Case Officer: Lewis Knox

Applicant: Mr Paul Lowbridge

Proposal: Installation of an air source heat pump to the rear of the property

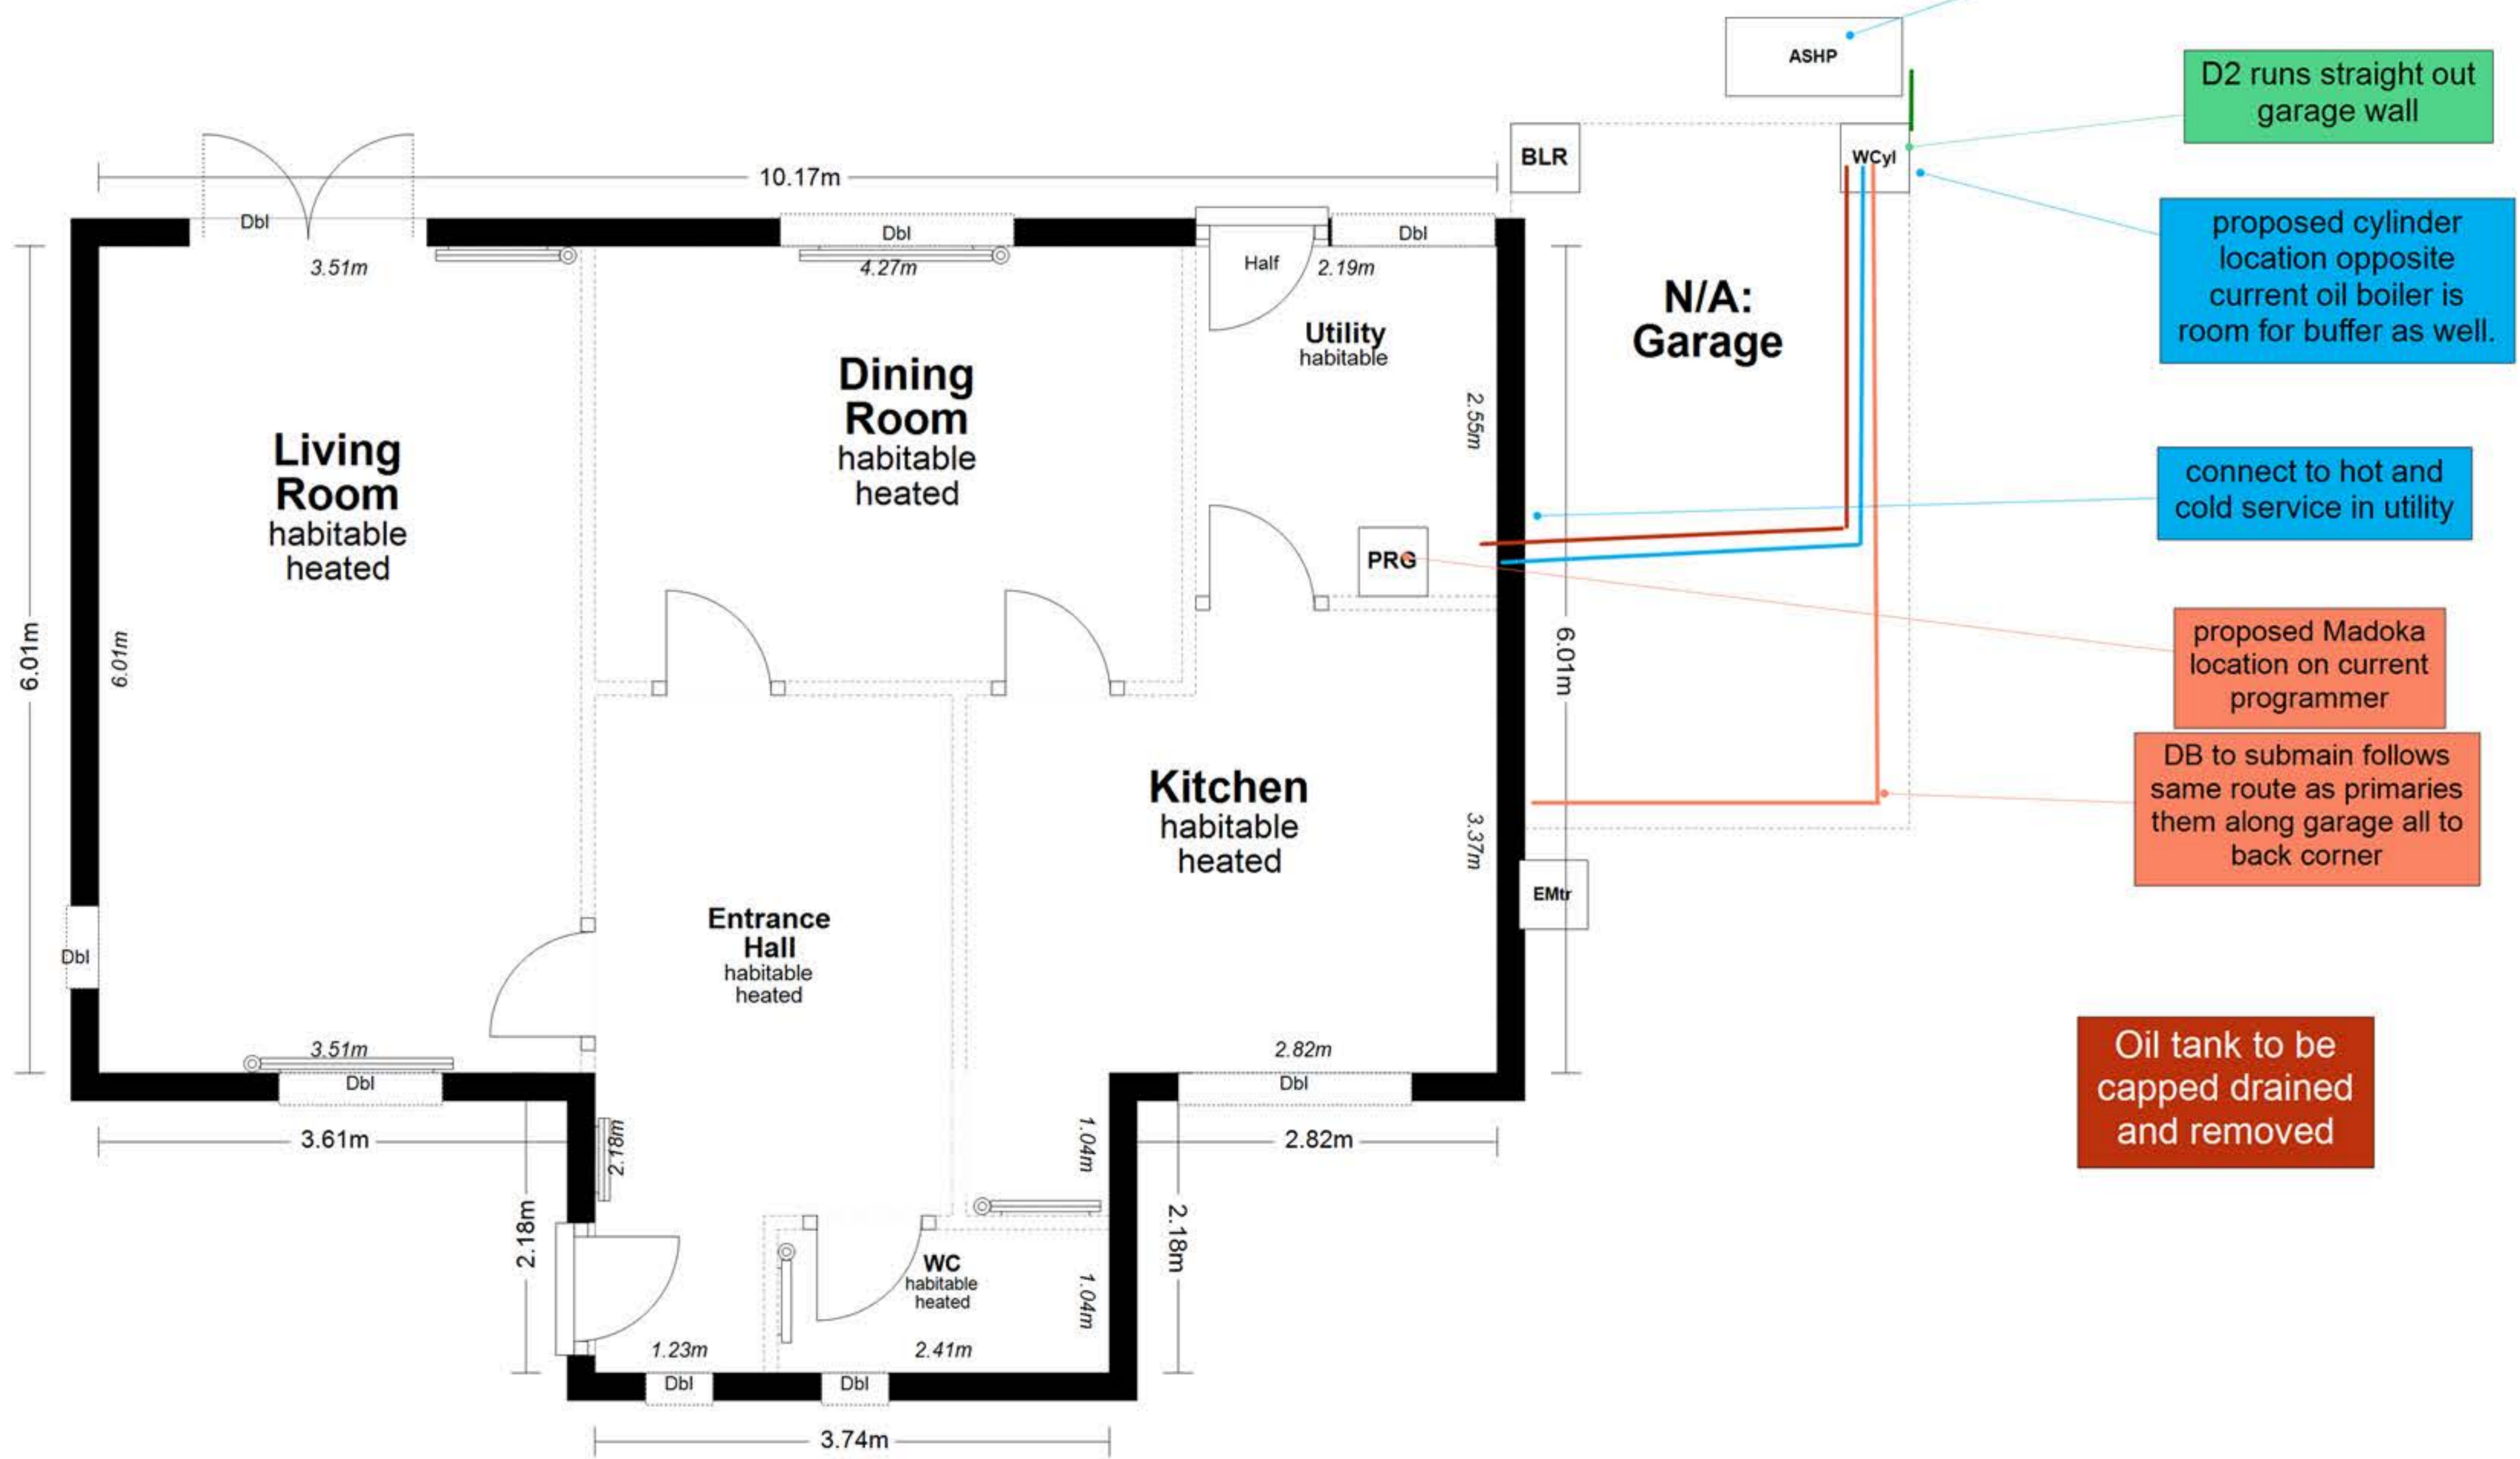
The application relates to amended plans received 25.09.2023 which altered the positioning of the heat pump from the rear of the garage on the northern side of the property to the southern side of the garden.

- Concerns were raised during the publicity of the application regarding potential noise disturbance to the nearest neighbour to the north; Pippins. Amended plans were subsequently received which moved the proposed positioning of the ASHP away from the shared boundary with this neighbour and reposition it to the southern boundary of the property.

- CDC Environmental Health Officers were consulted on the application and have conducted a site visit at the property. The site visit was undertaken in conjunction with the completed MCS Planning Standard assessment for ASHPs, given the information provided CDC environmental health officers have raised no objections to the proposals in terms of noise nuisance.

- It is considered that the positioning of the ASHP away from neighbouring properties would not cause excessive nuisance to neighbouring dwellings despite the slightly increased decibel level of the proposed ASHP.

- The ASHP would be small in its scale and would not exceed the dimensions of the boundary treatments between the application site and the neighbouring Golden Furlong to the south and as such it would not impact on neighbouring residents in terms of loss of light, loss of outlook or overbearing.
